Medworth Energy from Waste Combined Heat and Power Facility

PINS ref. EN010110
Document Reference Vol.16.4a
Revision: 1.0
Deadline: 7
August 2023

Applicant's comments on the Deadline 6 Submissions: Part 1 Statutory Parties

**Figure 10.1iii**  
**New Bridge Lane access proposal**

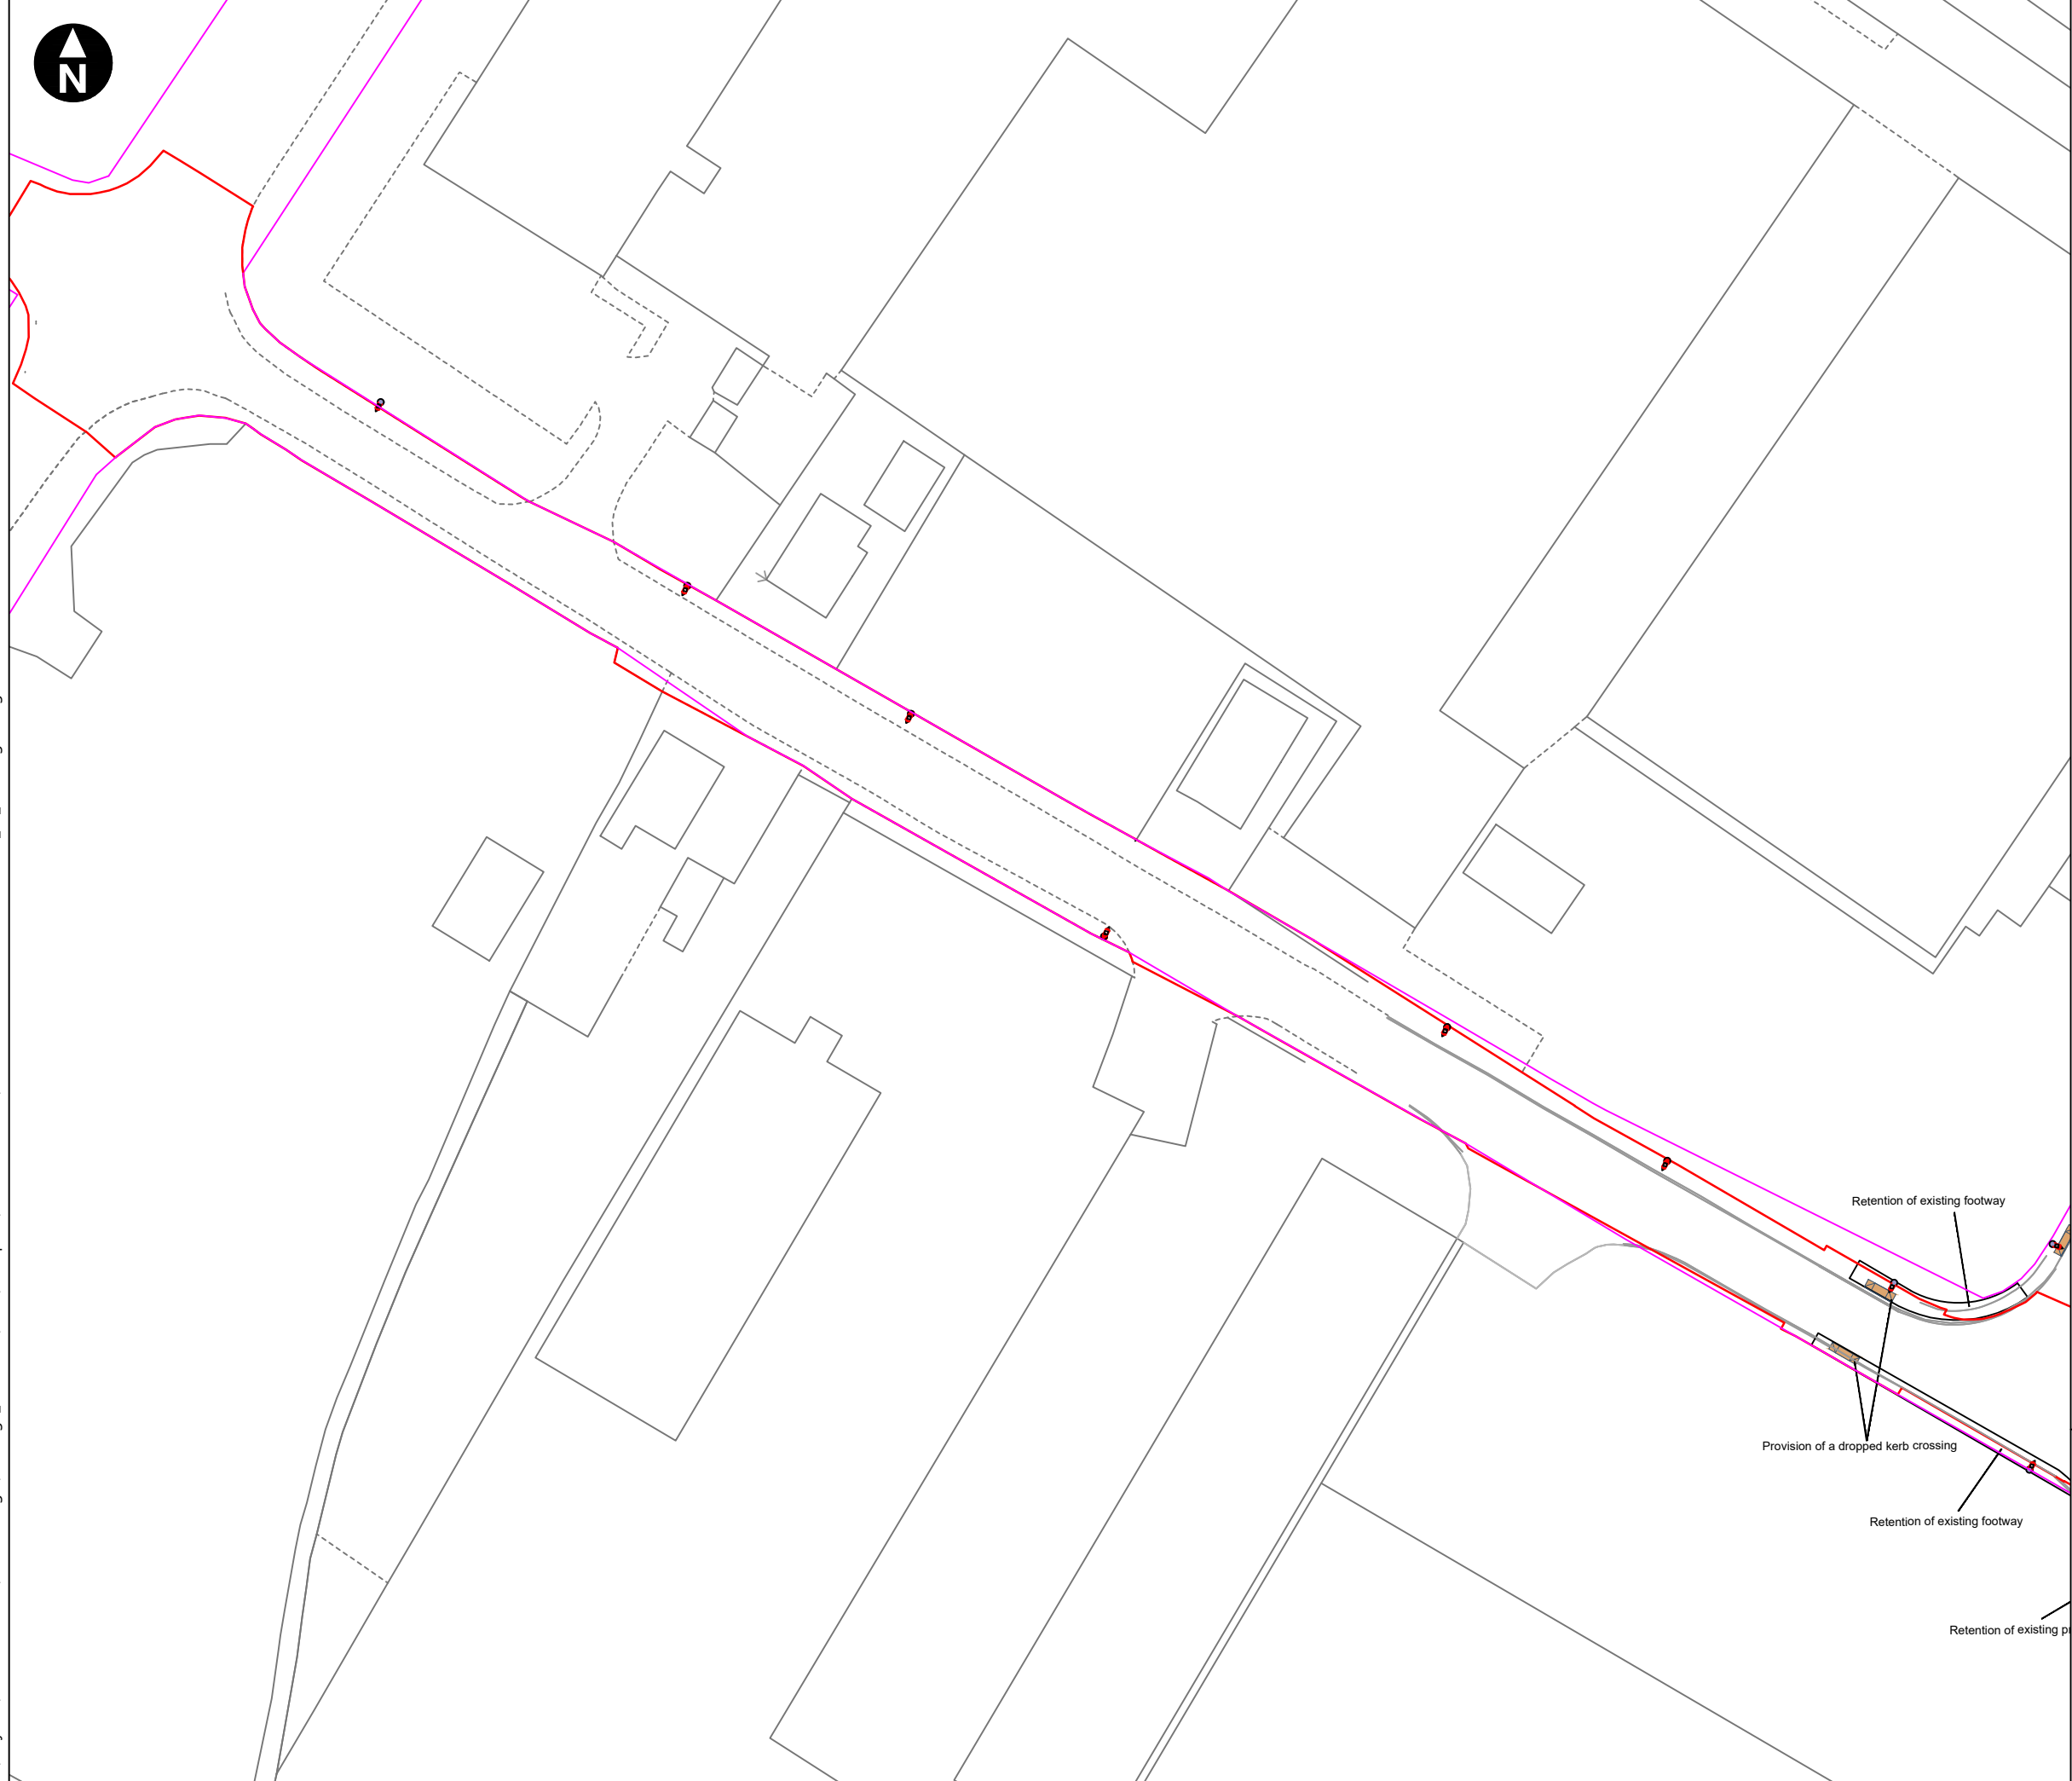
Topic/Para	Representation	Applicant Comment
<p>10 New Bridge Lane</p> <p>29th – 33rd paras</p>	<p>10 New Bridge Lane</p> <p>Regarding 10 New Bridge Lane, the Applicant asserts that the rear patio would not have a view of the Proposed Development, and that the front of the dwelling is not used and therefore is not impacted in terms of visual amenity at</p>	<p>The landscape and visual impact of an EfW CHP facility is not unique and there are a number of examples of a similar scale EfW's located in more sensitive landscape contexts than the Proposed Development across the U.K including the operational EfW's at Javelin Park, Gloucestershire and in Bridgewater, Somerset. The Boston EfW in Lincolnshire was recently consented by the Secretary of State, located in The Haven and The Wash SPA.</p> <p>With regard to NPS EN-1 paragraph 5.9.15 it is recognised that the scale of nationally significant infrastructure projects is such that they will often be visible within many miles of the site of the proposed infrastructure and as quoted by CCC that the decision-maker must establish whether any adverse impact on the landscape would be so damaging that it is not offset by the benefits (including need) of the project. The Applicant's assessment is that the landscape and visual effects identified and reported with ES Chapter 9 Landscape and Visual (Volume 6.3) [APP-036] are not so significant as to outweigh the benefits of the project. The planning balance set out within the Planning Statement (Volume 7.1) [APP-091] concludes that with regard to the landscape and visual effects, that the balance lies firmly with the need for the Proposed Development.</p> <p>The Applicant would disagree with the point made by CCC that the type of infrastructure is unique within the landscape. The landscape within the area defined as the Landscape and Visual study area used for the LVIA includes a number of tall vertical elements such as wind farms, pylons and towers.</p> <p>At ISH6, Mr Furber, on behalf of the Applicant, covered in detail at page 14 and 15 of the Written Summary of the Applicant's Oral Submissions at ISH6, Document 15.2, [REP6-024], why the Applicant disagreed with the Councils conclusions.</p>

Topic/Para	Representation	Applicant Comment
	<p>decade to become effective, according to the Applicant – the Councils disagree, and do not believe this planting would be effective in this way.</p> <p>Mr Flatman noted that traffic movements outside 10 New Bridge Lane would be seen above the proposed acoustic fencing, as would their lighting and lighting for the Proposed Development. These effects would be ever-present during operational hours. The residents may not wish to close their gate all the time. If the gate was open, they would have a clear view of the proposed development.</p> <p>Mr Flatman concluded that this scheme would breach the residential visual amenity threshold for this property, taking it beyond something which would be acceptable. The effects cannot be mitigated.</p>	<p>The ExA's attention is drawn to the planning consent permitting 10 New Bridge Lane; LPA Ref: F/YR05/0841/F (see Appendix A). This planning consent approved by FDC states "<i>The site lies in an area where residential development would only be permitted under exceptional circumstances...</i>" consequently it is limited to agricultural/forestry related occupancy only. Therefore, an owner/occupant of this property could not change how they use the property so as to significantly enlarge the amenity space at the rear of the property. Furthermore, any future planning application at this dwelling would need to consider the following material considerations.</p> <p>10 New Bridge Lane is:</p> <ul style="list-style-type: none"> • Located within a waste management safeguarding area for existing and future waste uses in the Cambridgeshire and Peterborough Minerals and Waste Local Plan 2036 (Oct 2021); • Allocated within the Broad Location for Growth, predominantly for business purposes in the Adopted Fenland Local Plan (May 2014); and • Part of a 67Ha area of land within Wisbech that is allocated for non-residential development (employment) site ref LP37.01, in the Emerging Fenland Local Plan (Draft Local Plan Consultation (Aug 2022)). <p>Concerning the gate to the acoustic fence, it will be a requirement of the noise mitigation that it remains closed when not in use. The gate will be an electronic sliding gate and it will be inspected from the highway each day by the Applicant as part of its daily round of site inspections. Any maintenance issues affecting the use of the gate will be attended to by the Applicant with the agreement of the owner/tenant.</p>

**Figure 10.1iv**  
**Cromwell Road/New Bridge Lane Signal Scheme - General arrangement**

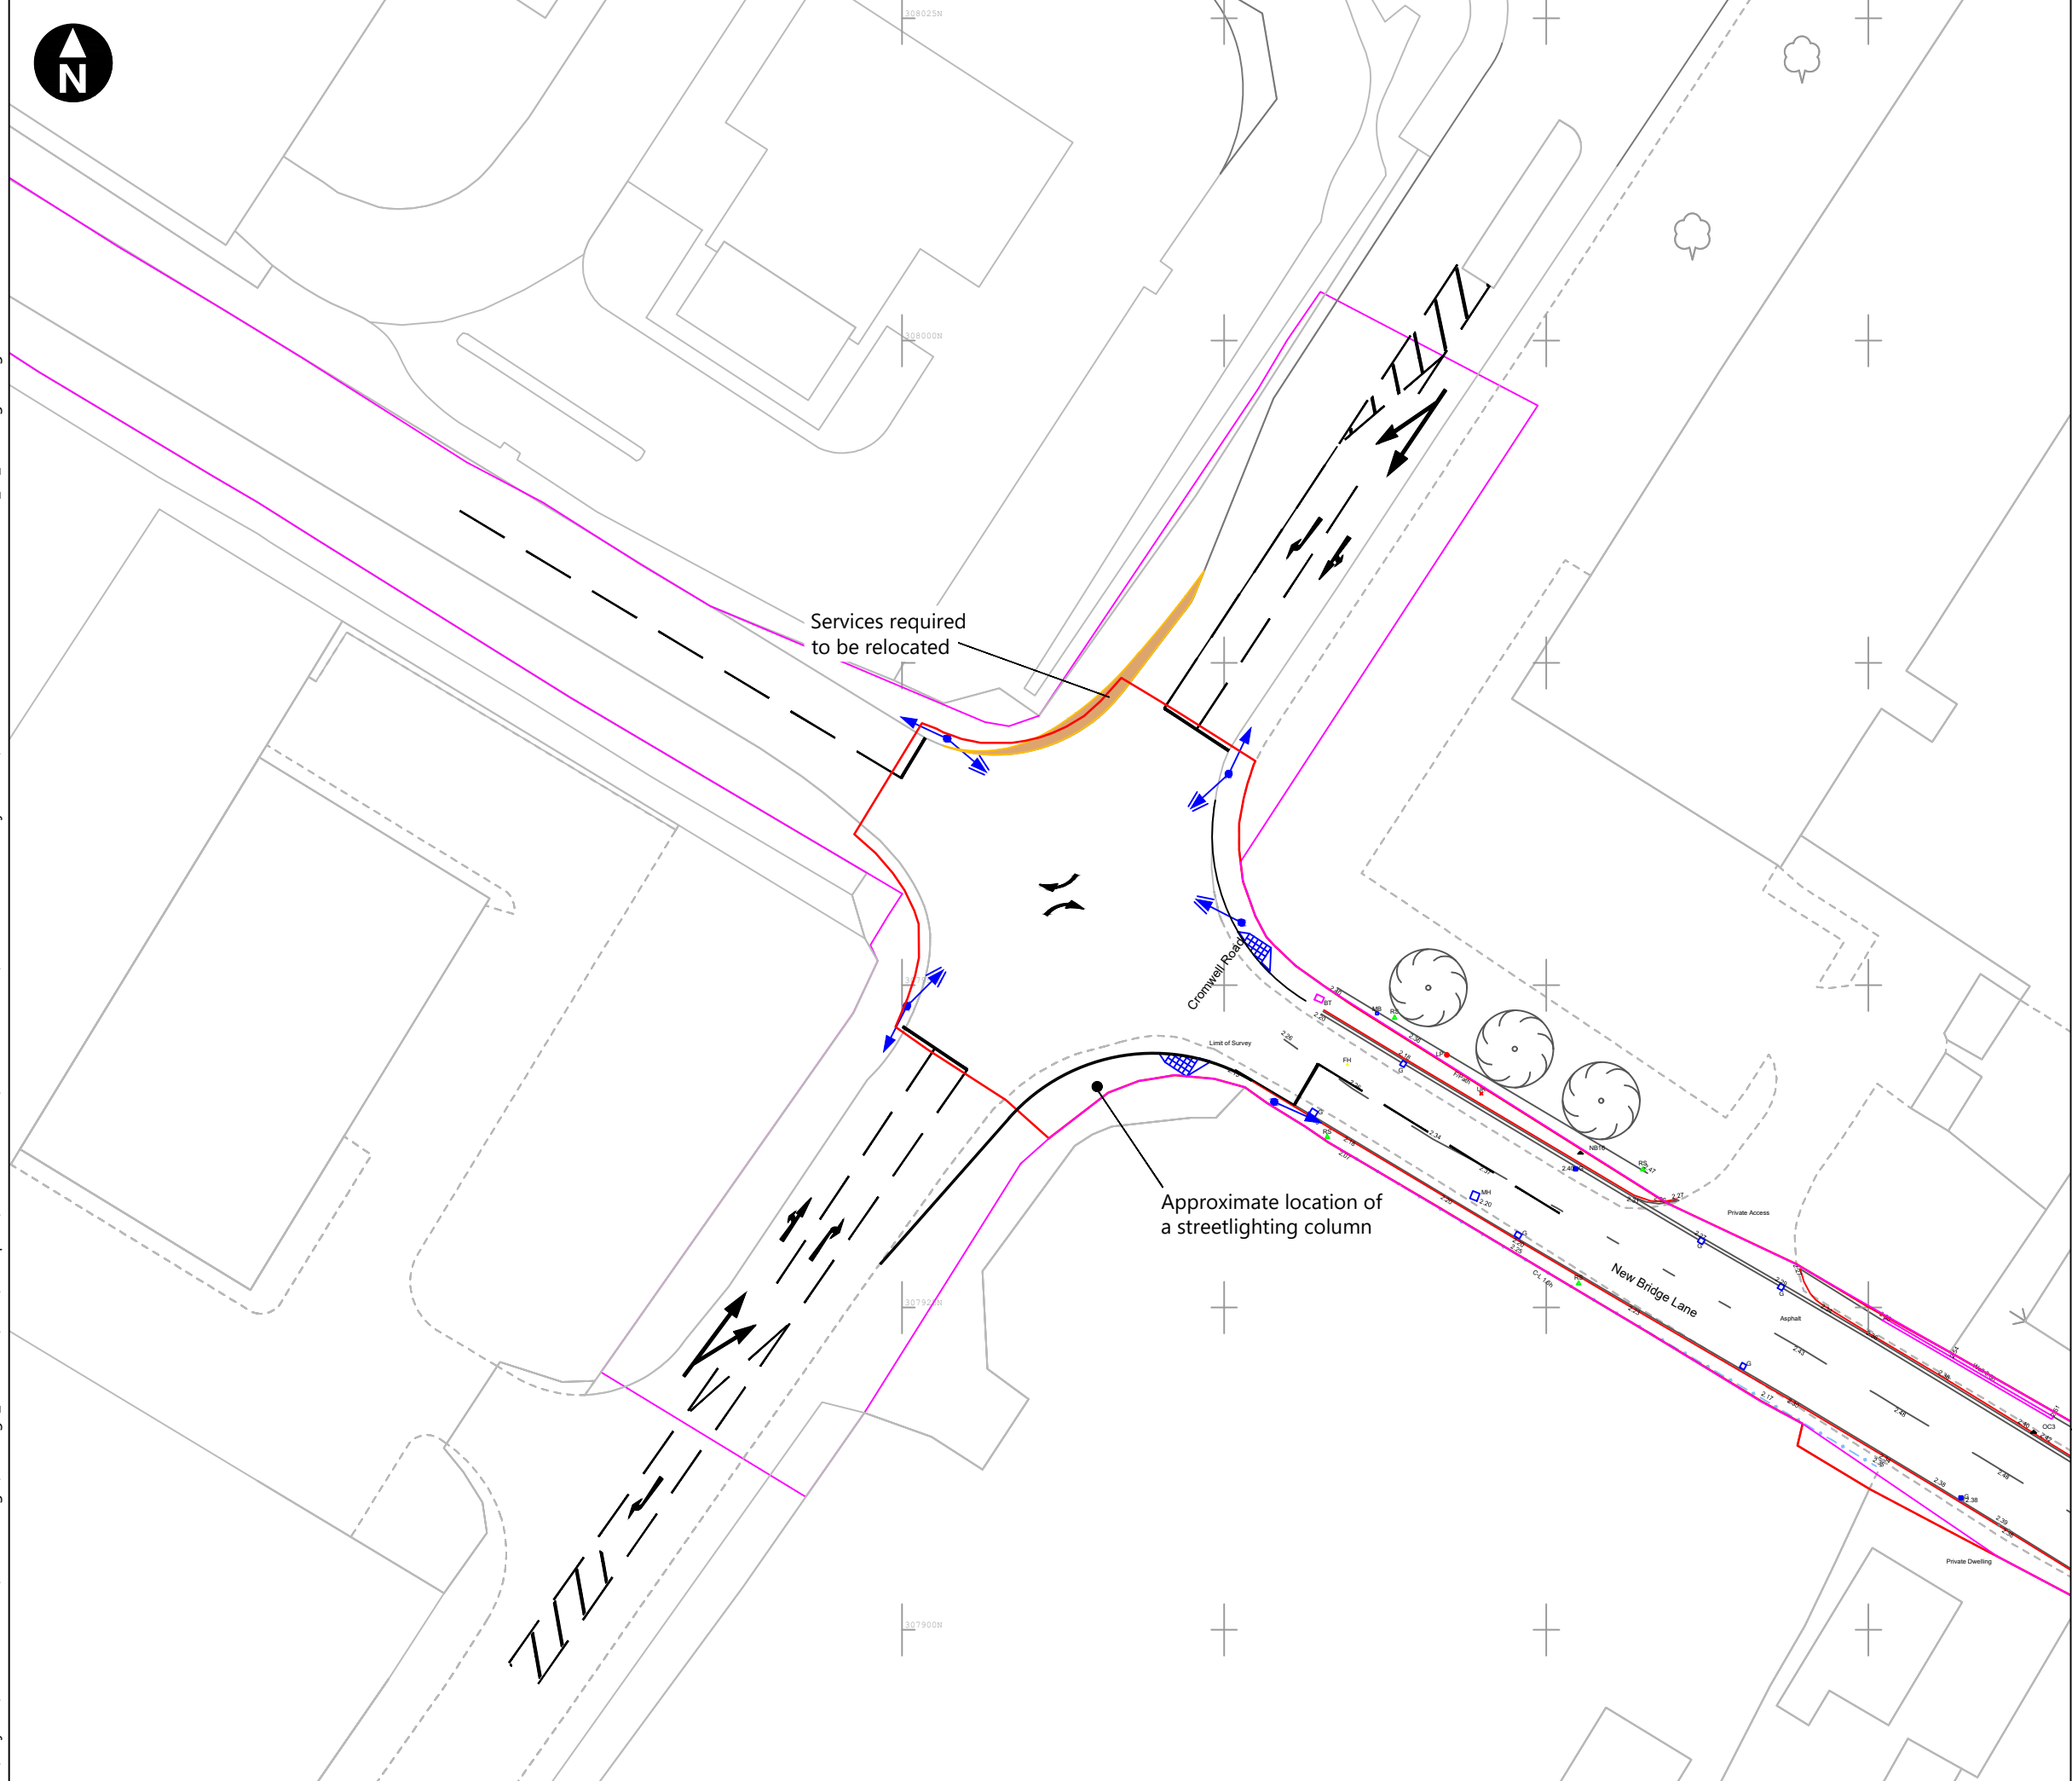
Topic/Para	Representation	Applicant Comment
Signal phasing at New Bridge Lane/Cromwell Road – Change Application 2 nd – 4 th paras	<p>Mr Fraser-Urquhart KC noted that two additional areas the Councils wished to comment on included the position regarding modelling of the effectiveness of the proposed signalised Cromwell Road/New Bridge Lane junction, and any other technical issues regarding this junction, and whether the intended change takes enough land to make this junction practicably functionable.</p> <p>Mr Jez Tuttle, Transport Assessment and Smart Journeys Manager, explained where matters stand with respect to the modelling of whether this proposed junction design would function. The Councils have reviewed the revised designs, and whilst the Councils are broadly happy with the flows the Applicant has used, albeit they have used some assumptions, they are concerned with some of the signal phasing, as it appears to allow right turn traffic from the South onto New Bridge Lane without stopping the southbound traffic from the north. This would allow the southbound traffic to cut across the northbound traffic's right turn. The Councils feel the southbound traffic would need to be stopped in all settings to allow the northbound traffic to turn right onto New Bridge Lane. The phasing diagrams submitted by the Applicant show the southbound traffic is not stopped in all settings currently. The staging needs to be completely separate so that the southbound from Wisbech traffic is stopped to allow the vehicles turning right into New Bridge Lane to do so safely.</p> <p>Mr Fraser-Urquhart KC asked Mr Tuttle to confirm whether there was any technical or practical reason why this could not be done. Mr Richard Ling Traffic Signals and Systems Manager confirmed that there is no reason why the staging cannot be changed and remodelled to show the manoeuvre safely.</p>	<p>The Applicant met with CCC on 06 July 2023 to discuss technical issues relating to the signalisation of the junction (Change 1). The Applicant has subsequently carried out further traffic modelling of the junction to incorporate a separate stage for right turns into New Bridge Lane as requested by CCC. The outputs from this modelling, together with an updated phasing diagram were shared with CCC on 24 July and are provided in an updated Transport Assessment Change Application Addendum (Volume 13.3) (Rev 2) submitted at Deadline 7.</p> <p>CCC confirmed at a meeting on the 02 August 2023 that the signalisation modelling of Change 1 was suitable, subject to the detailed design.</p> <p>The Applicant is confident that Works No. 4A which incorporates the Change Application dated 05 June 2023, including the signalisation, and associated cabling and ducting works, can be delivered within the Order limits. This position is evidenced by the:</p> <ul style="list-style-type: none"> • vehicle tracking issued to CCC and submitted with the Applicant's Change Request, see Figure 2.1, Non-Statutory Consultation: Proposed Changes Statement of Purpose, Rev 1, June 2023 • Figure 10.1iv in the Outline CTMP (Rev 7) (Volume 6.4) submitted at Deadline 7 displaying the cable ducting for the signalisation; and • Figures 10.1x – 10.1xii Additional Cross-section plans of New Bridge Lane were provided to CCC to provide further assurance on this point. CCC has confirmed its agreement.

Topic/Para	Representation	Applicant Comment
Order Limits at the New Bridge Lane/Cromwell Road junction 5 th para	Mr Daniel Ashman, Asset Information Searches Manager, then explained that the Councils question whether the plans include sufficient land for the required improvements to the New Bridge Lane/Cromwell Road junction. Firstly, the additional land required by the Applicant on the carriageways of both New Bridge Lane and Cromwell Road does not achieve a sufficient distance back from the proposed stop lines that would be installed at the revised junction. A minimum distance of 50m is required, to ensure appropriate road surfaces and sensors can be installed, at the correct locations of the junction. This should be included within the expanded DCO boundary.	The Applicant's response on this point can be found in the Written Summary of the Applicant's Oral Submissions at ISH6 (Volume 15.2) [REP6-024] Agenda Item 5c.

Order Limits at the New Bridge Lane/Cromwell Road junction 6 th para	Second, on the western side of the crossroads, on the land that borders the Murkett's car garage, the DCO boundary has been expanded slightly but there appears to be limited space in one area.	The Applicant's response on this point can be found in the Written Summary of the Applicant's Oral Submissions at ISH6 (Volume 15.2) [REP6-024] Agenda Item 5c. The response is substantiated by the Applicant giving consideration to the location of the cabling that would be required to operate the signalisation. An outline design demonstrates that cabling could be accommodated within the order limits, see below with the full figure to be found within the Outline Construction Traffic Management Plan (Volume 6.4) Figure 10.1iv submitted at Deadline 7.
